From: Martyn White
Sent: 24 June 2019 12:22
To: Planning.Responses
Cc: Anita Gardner
Subject: AB/48/19/PL & AB/49/19/L

AB/48/19/PL & AB/49/19/L

Listed building consent for internal and external alterations to facilitate the change of use of upper floors to a single, four bedroomed residential unit [use class C3a] and ground floor to a commercial unit (use classes A1,A2 & B1a).

**EXISTING &
PROPOSED ROOF
PLAN**

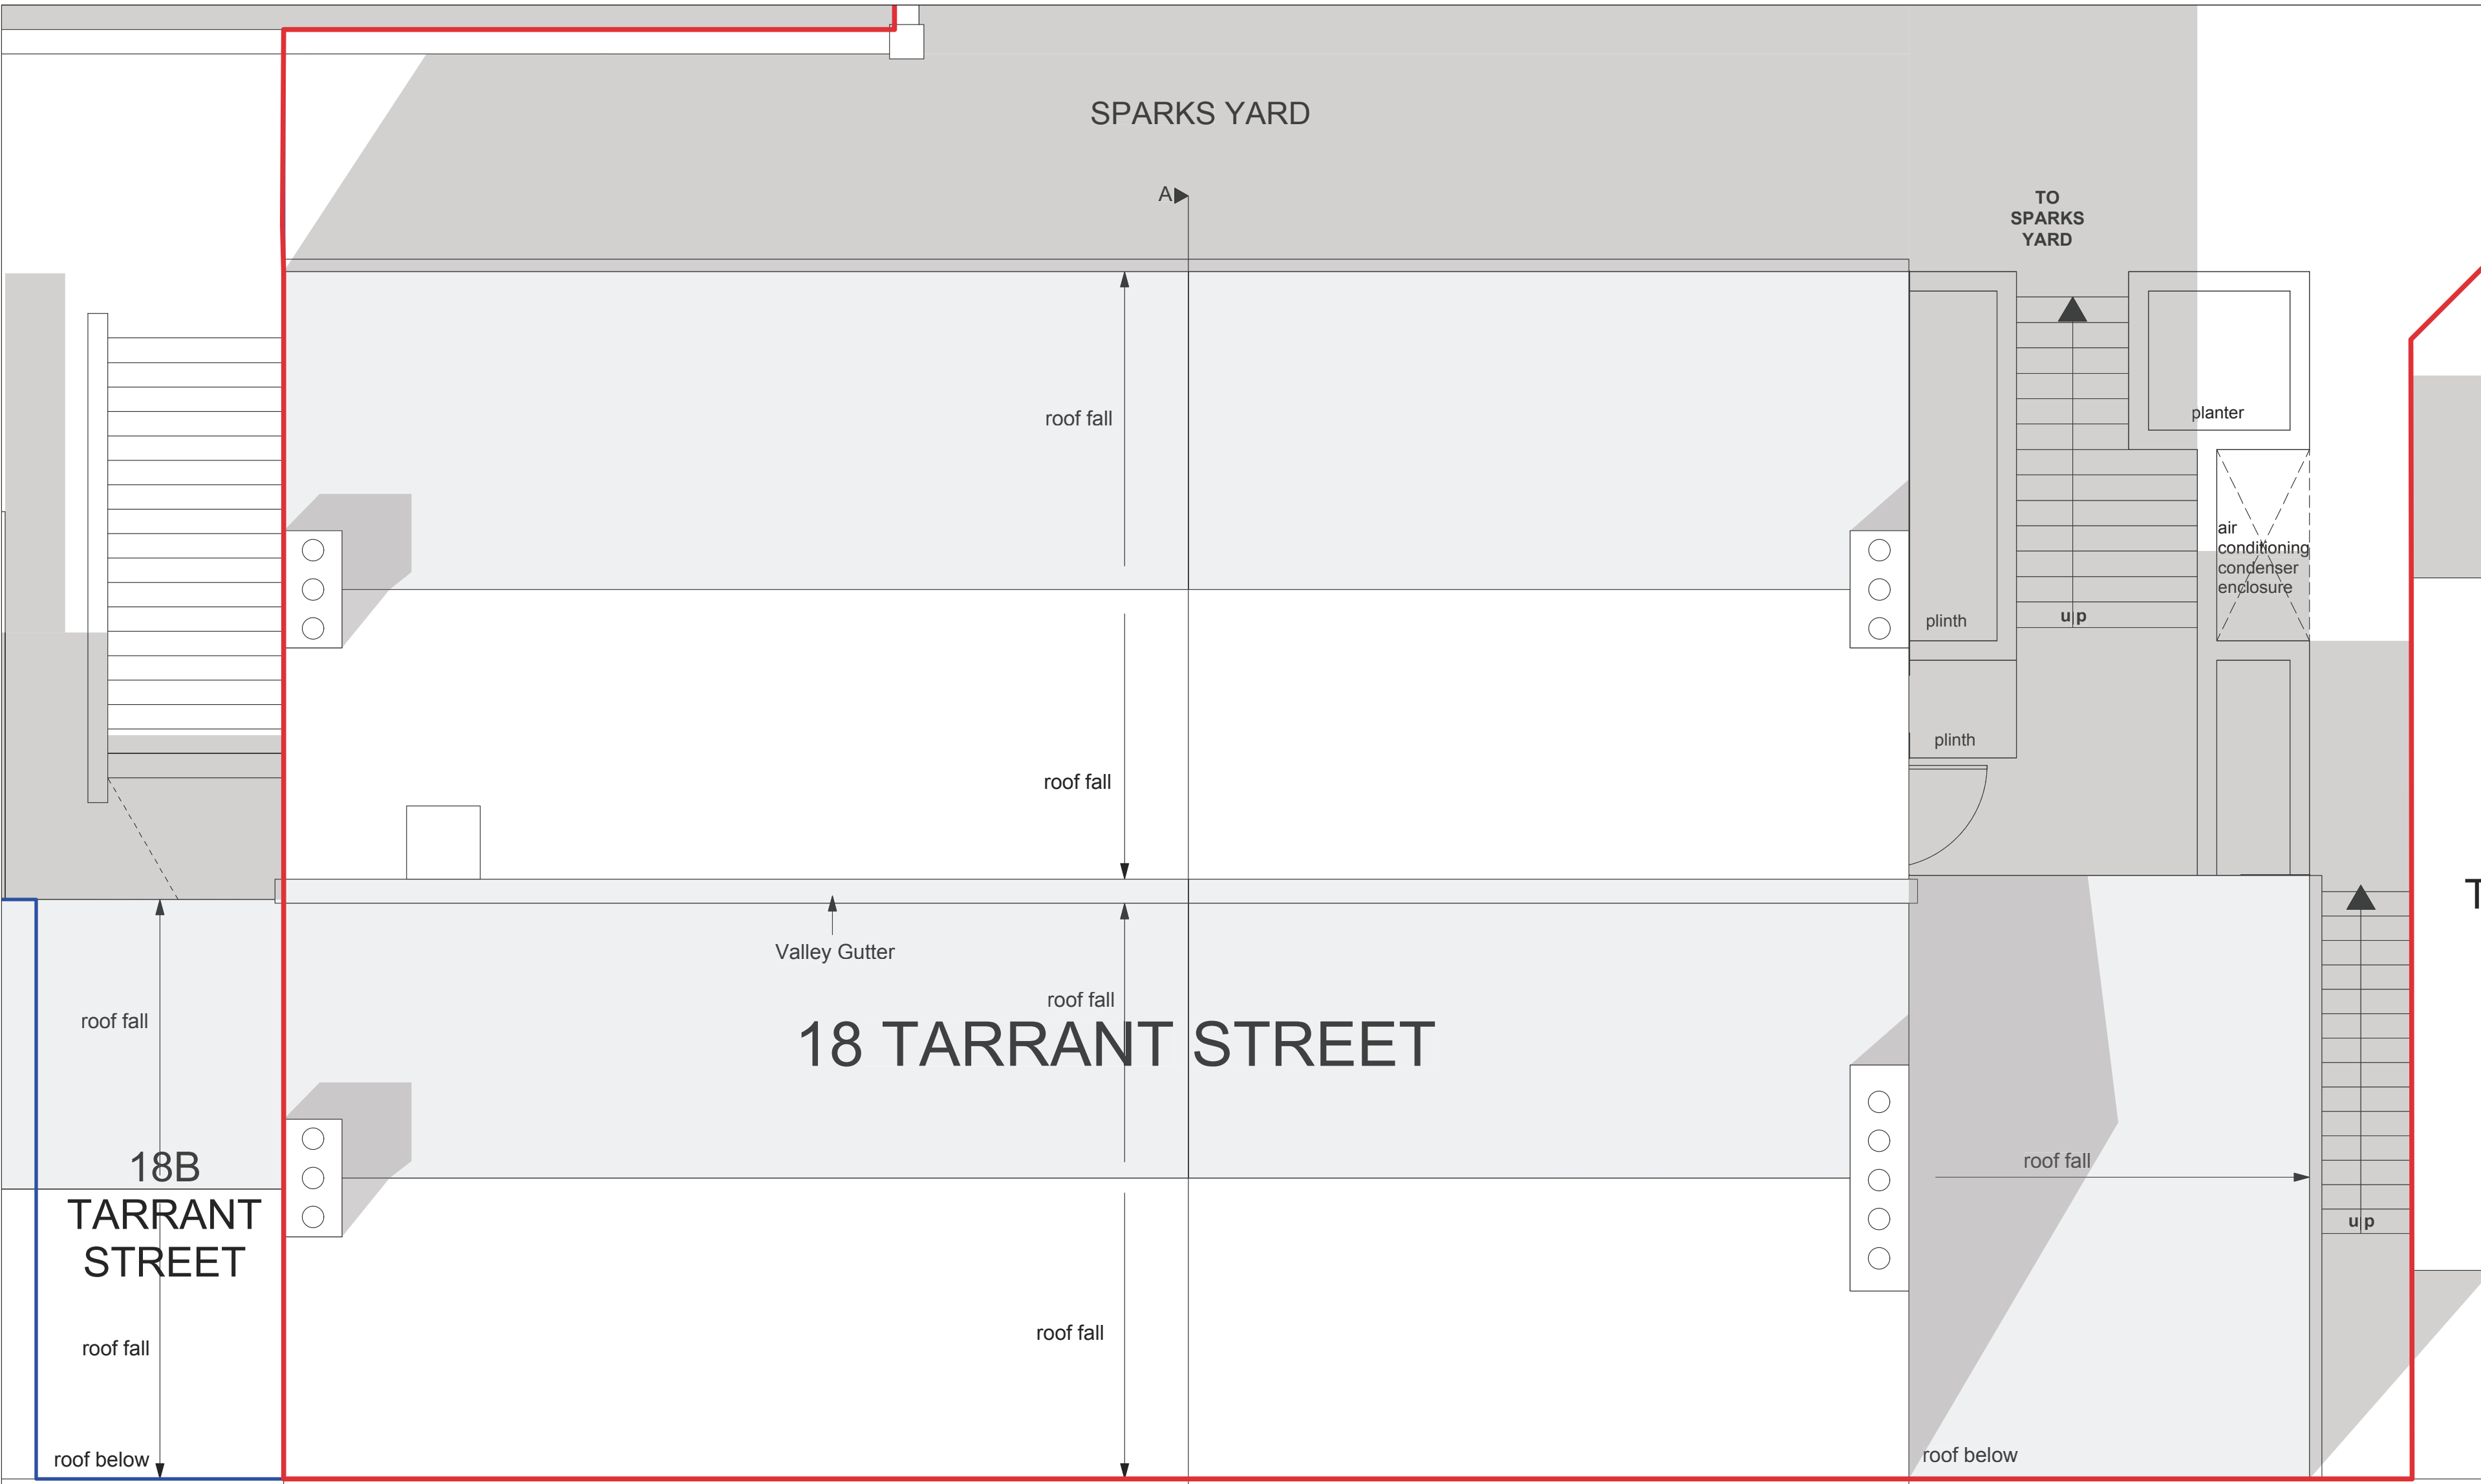
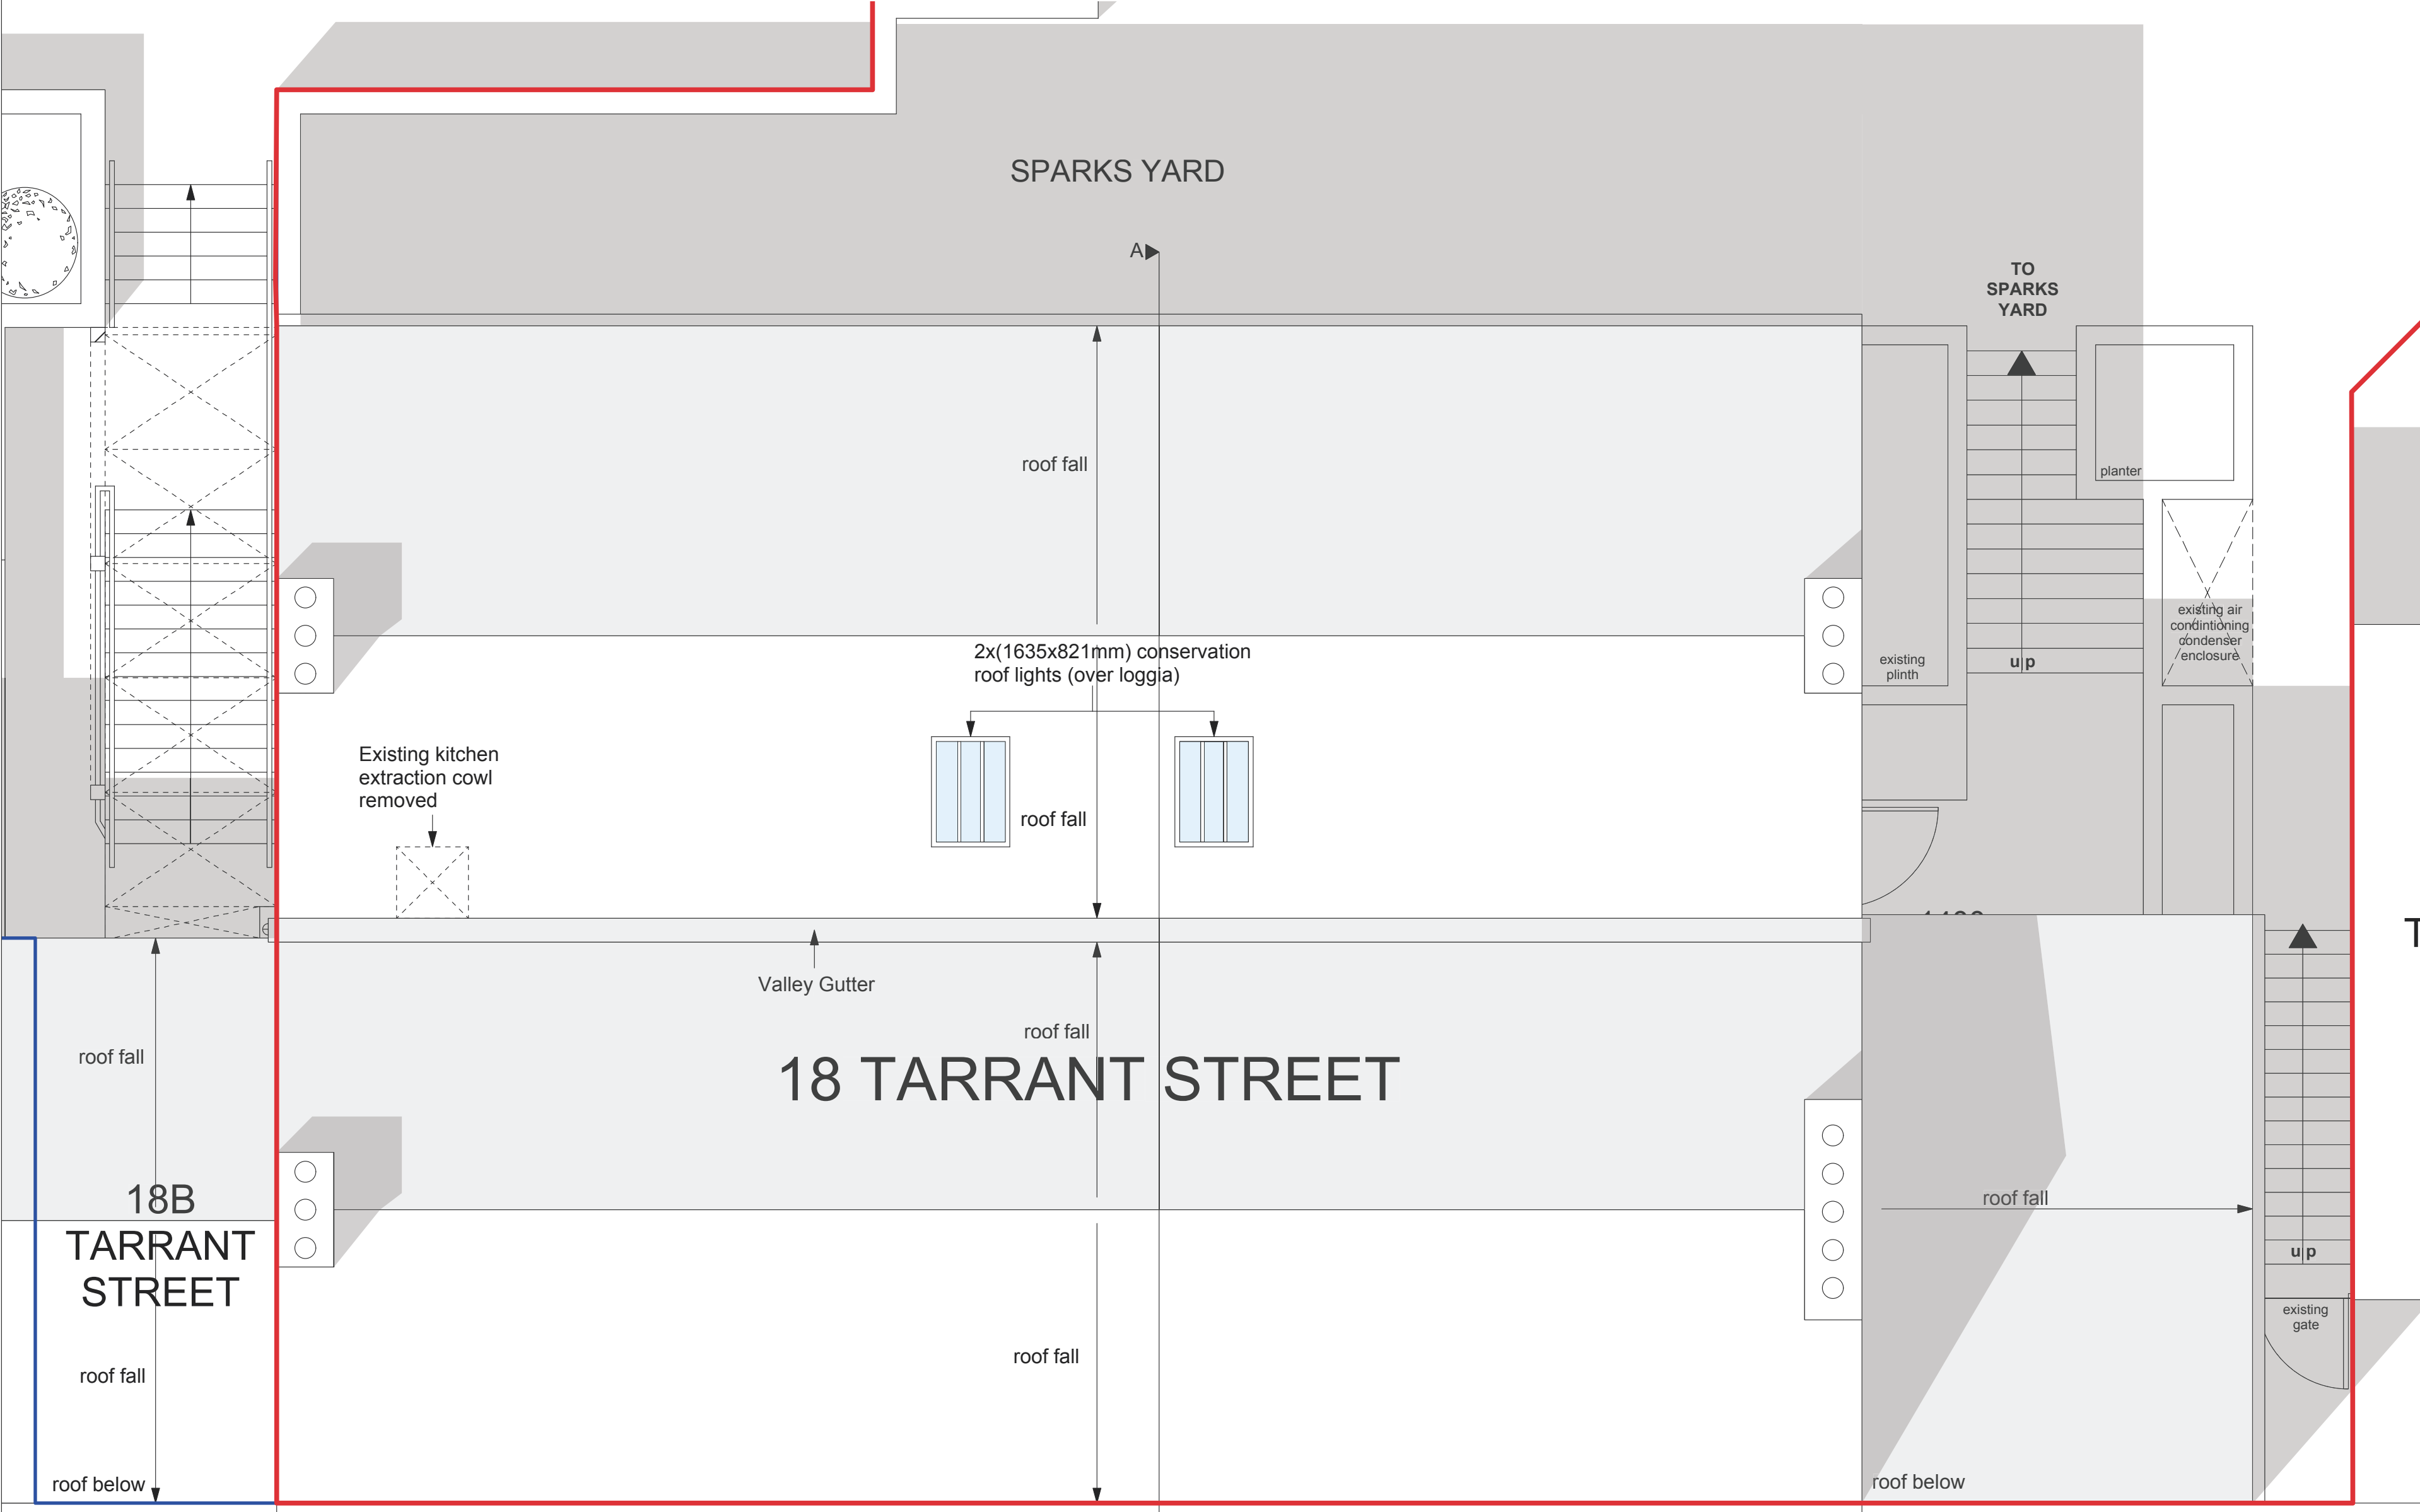
The rooflights will not be visible from the street-scene, and are of a conservation standard. The number of them will ensure that it will not result in the loss of any significant amount of historic fabric.
